Subject: Request for Additional Information

The department requests that you provide additional information/clarification about matters relating to the proposed modification of the Cowal Gold Operations Underground Development (SSD-10367 Mod 1), as outlined below.

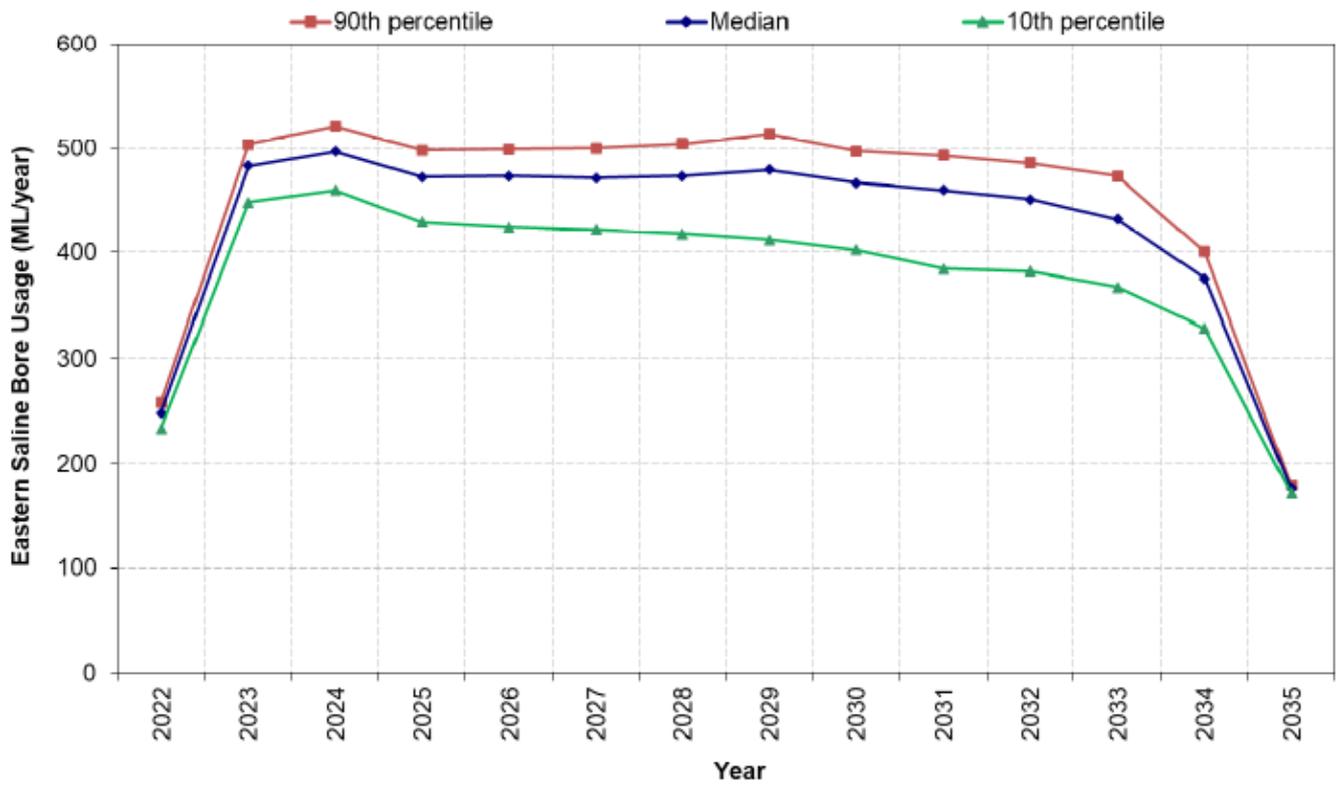
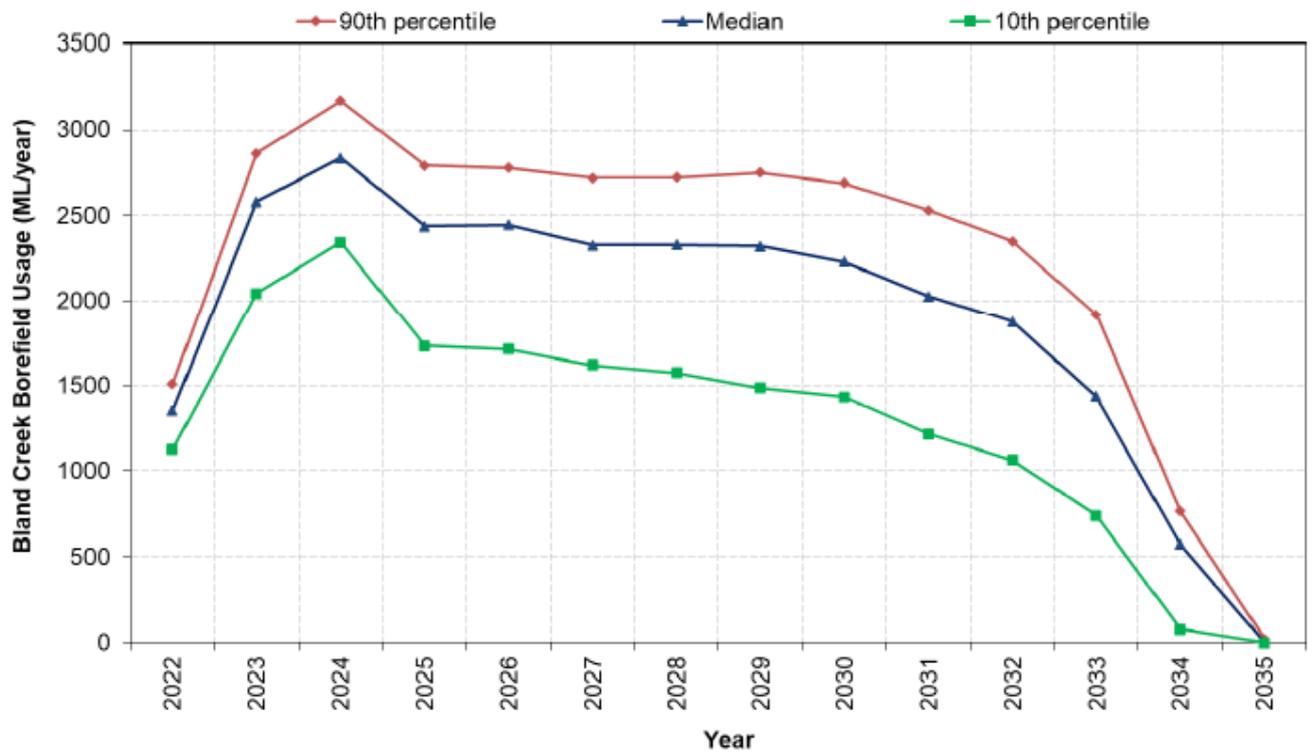
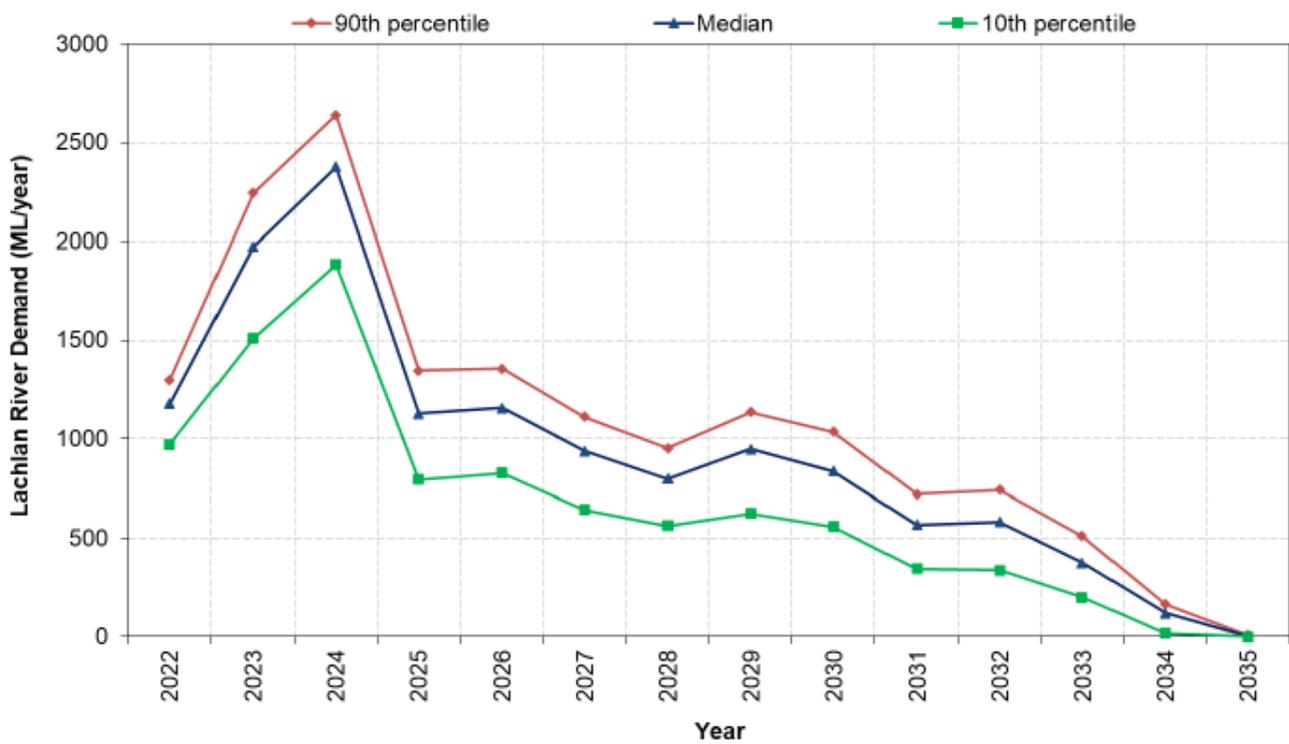
- Section 6.4 of the modification report refers to an increased “processing” rate as a reason for the decreased demand from external water sources. Please clarify this, given the proposed modification does not involve an increase in the processing rate.
- Please provide a table comparing the approved and predicted water take from each water source.
- Please provide an updated figure to replace that shown in Appendix 2 of the development consent.
